From: Nicola Spencer on behalf of Planning.Responses
Sent: 31 July 2012 14:24
To: Karen Garner
Subject: FW: Further Information required to validate application BR/197/12/L - [Your ref: [application/reference/agent_ref]]
Attachments: Block.pdf

From: planning.responses@arun.gov.uk [<mailto:planning.responses@arun.gov.uk>]
Sent: 27 July 2012 16:02
To: [REDACTED]
Subject: Further Information required to validate application BR/197/12/L - [Your ref: [application/reference/agent_ref]]

Item ref	Quantity	Title/Name, designation, material, dimension etc			Article No./Reference
Designed by JD		Checked by	Approved by - date	File name	Date
Parkside, Hotham Park					July 2012
Small Alterations					Scale
03					1:500
Edition					Sheet
0

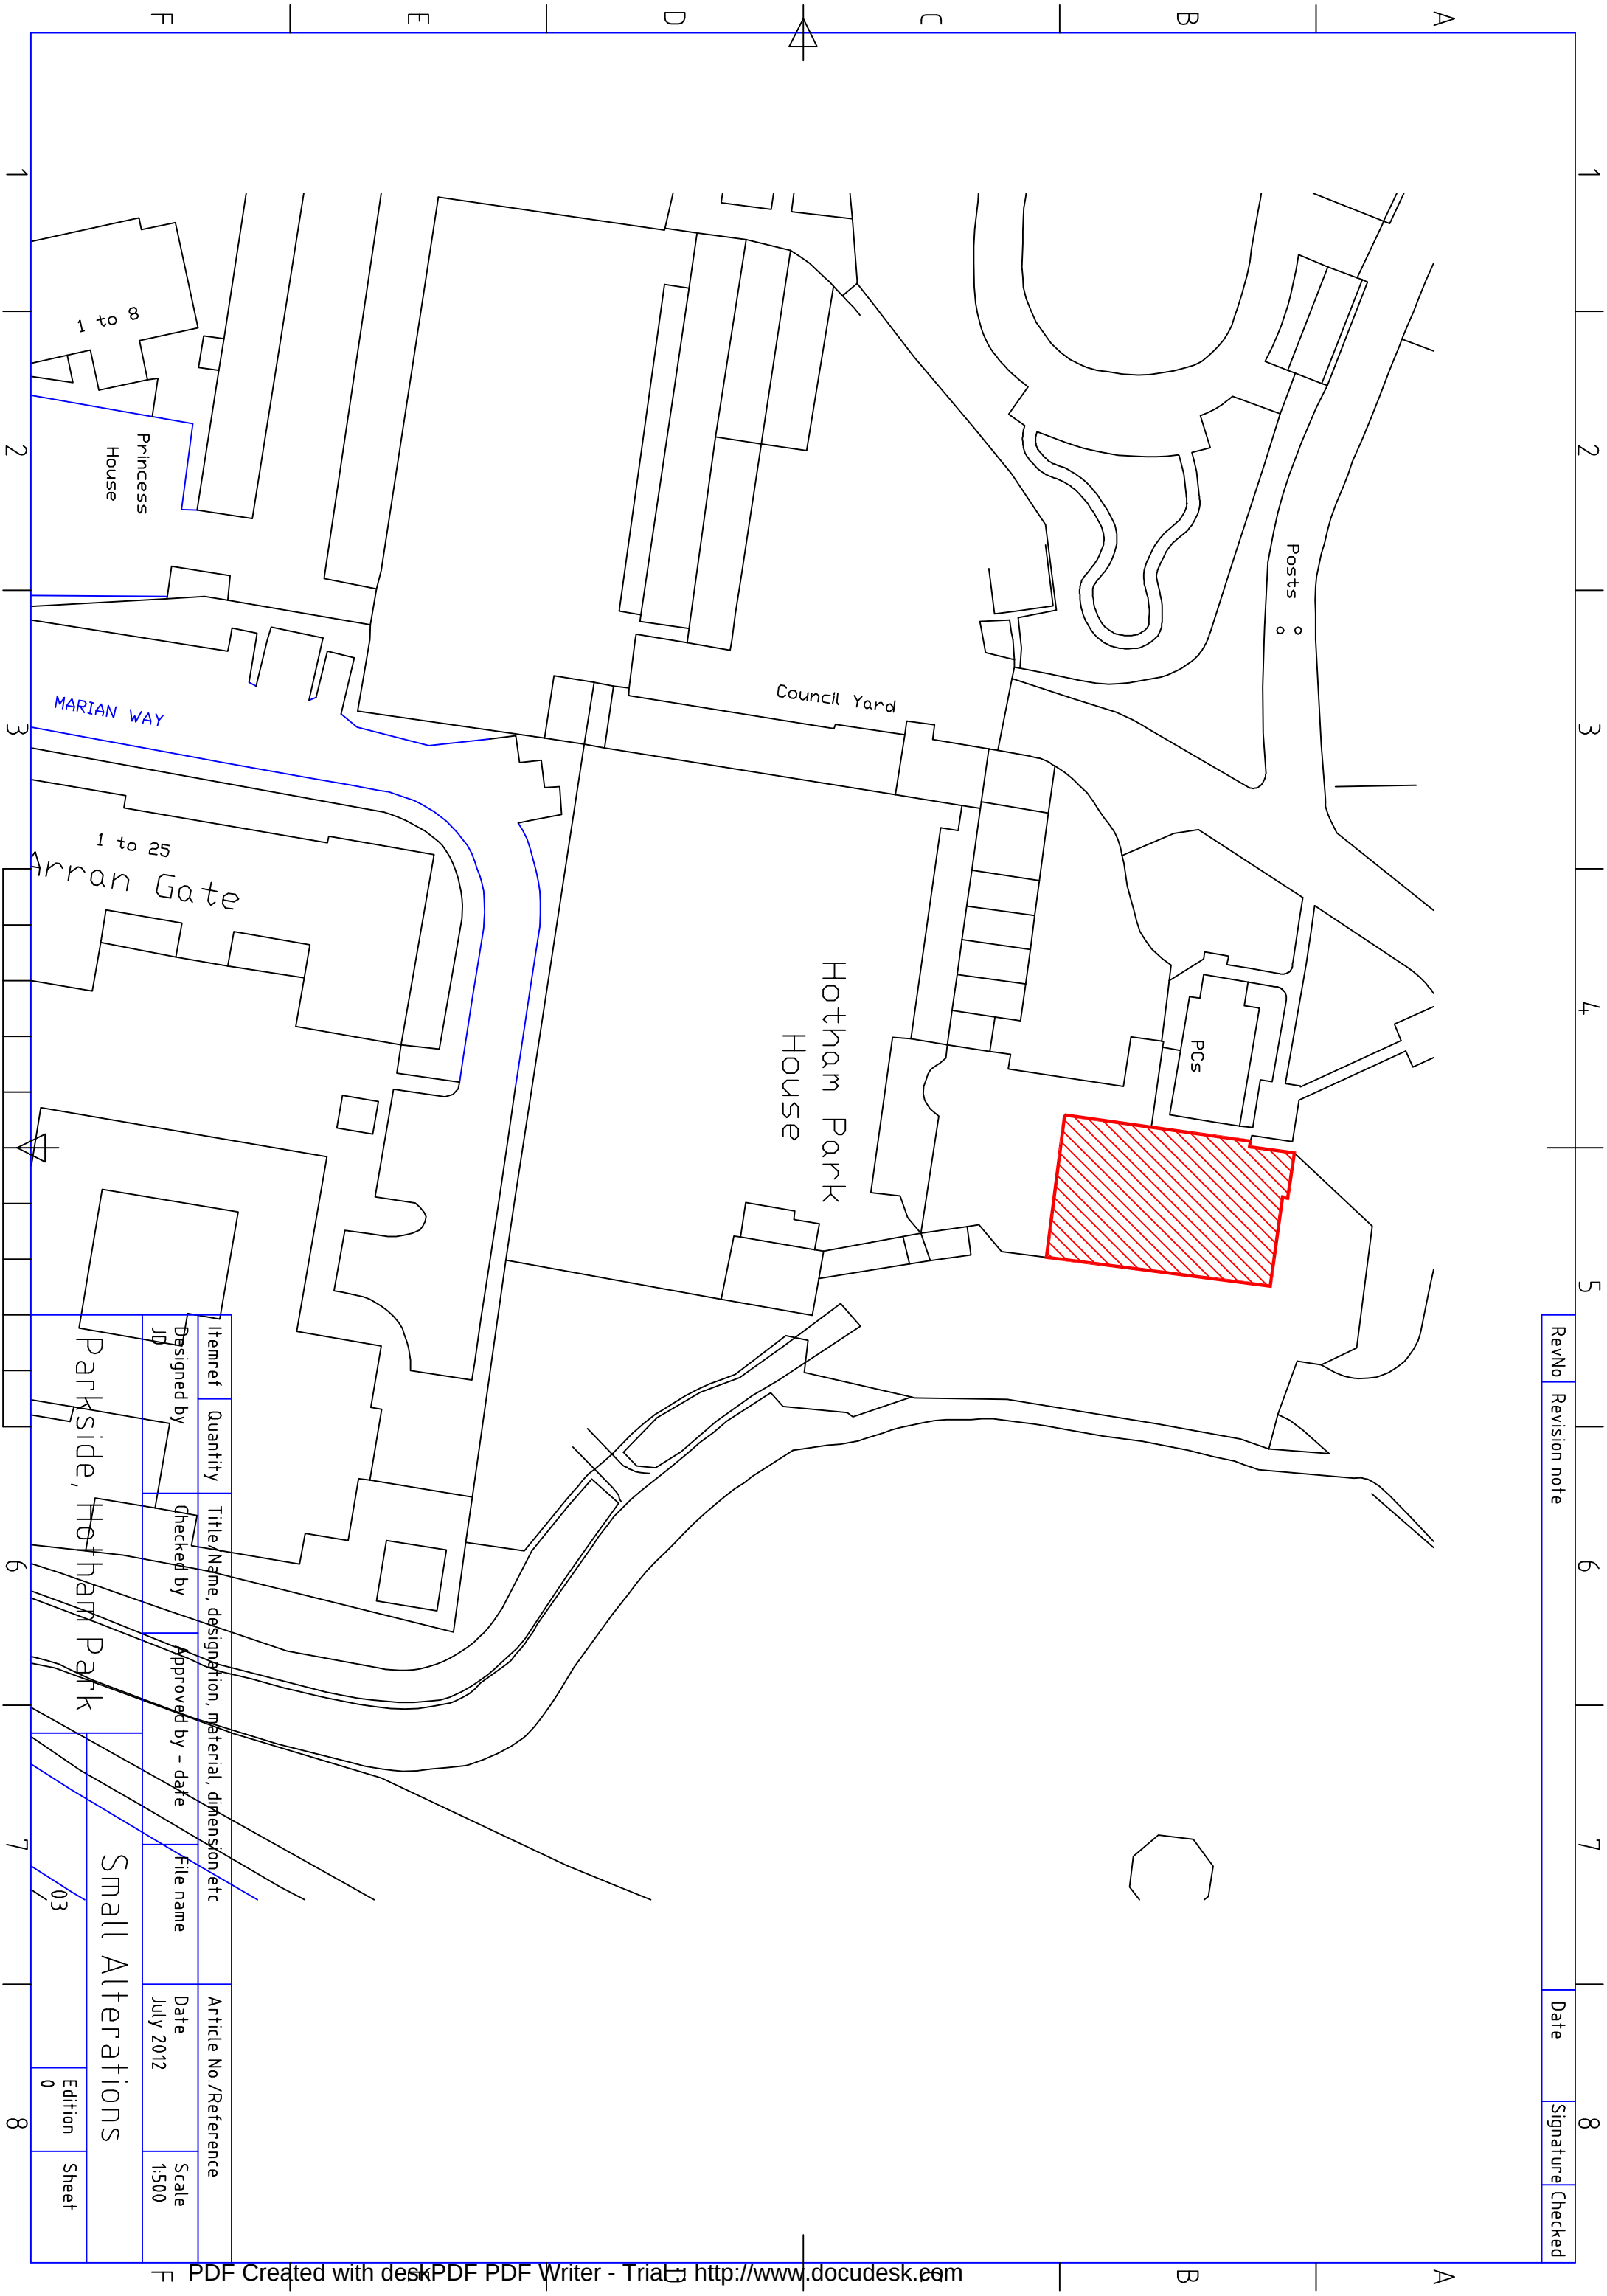
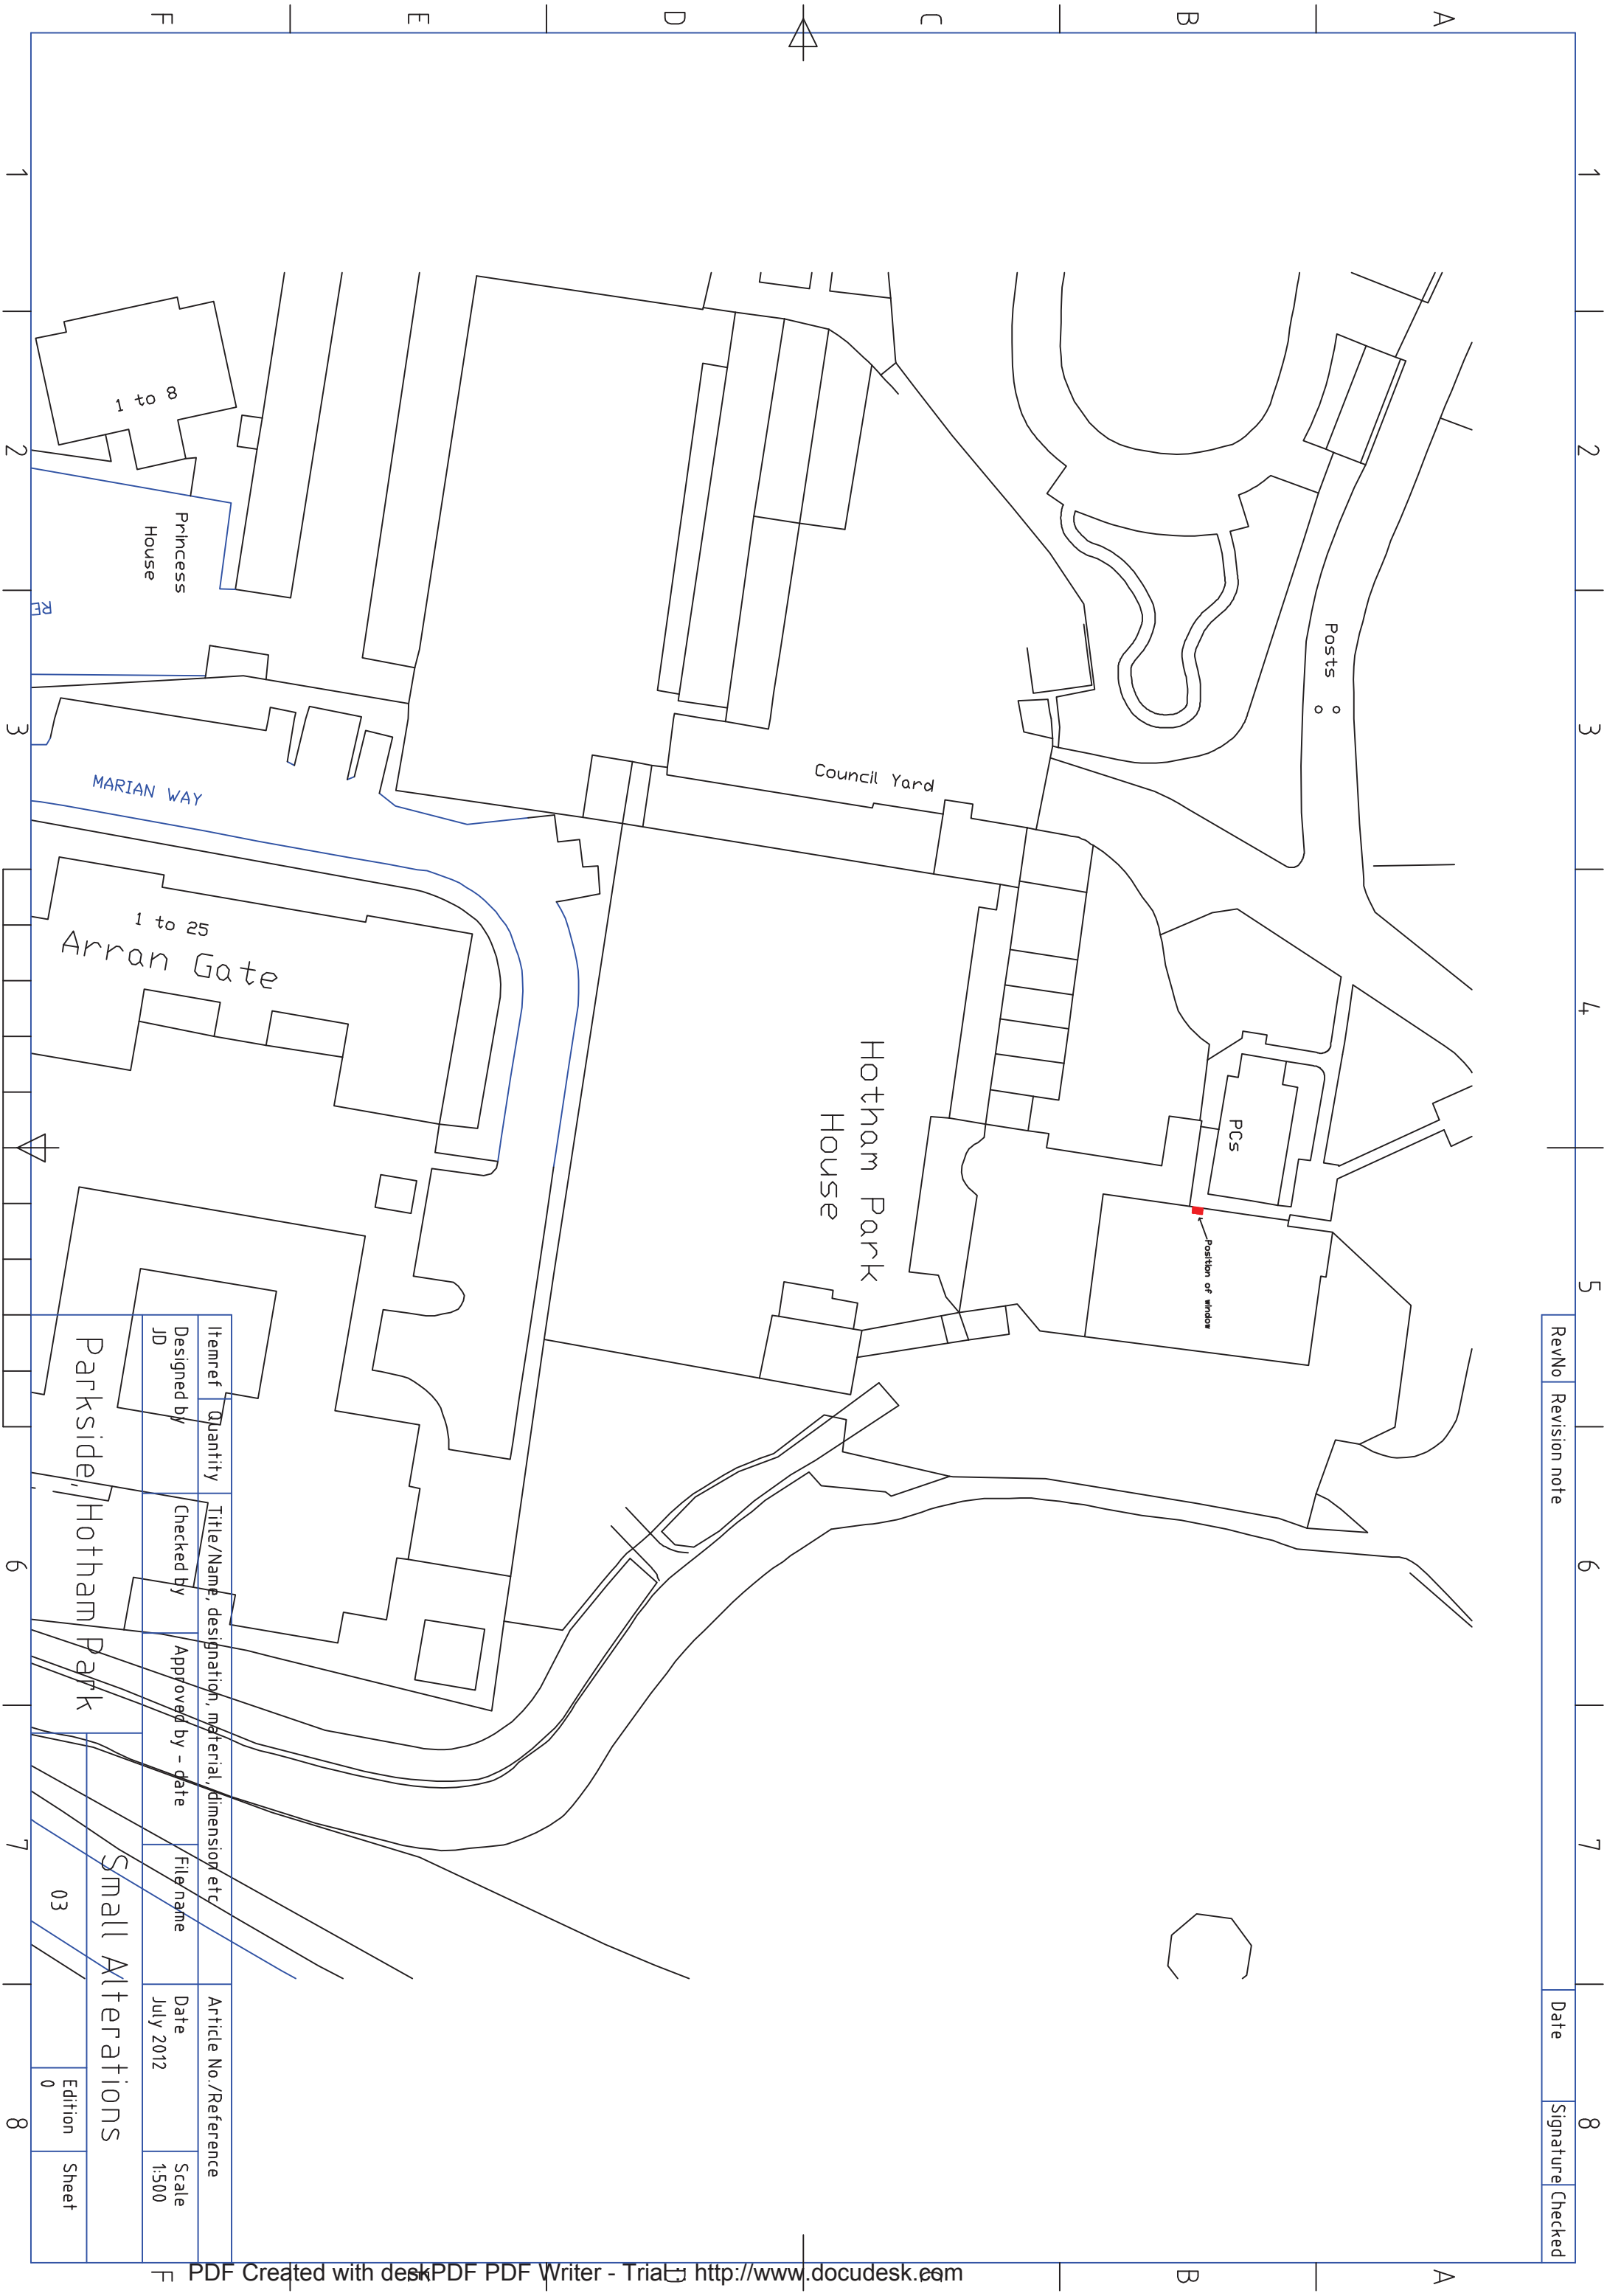
confirmed acceptance of the amended description.
 confirmed the applicant should be yourself
 Please submit amended block plans to show the position of the proposed window to be Enlarged. Attached
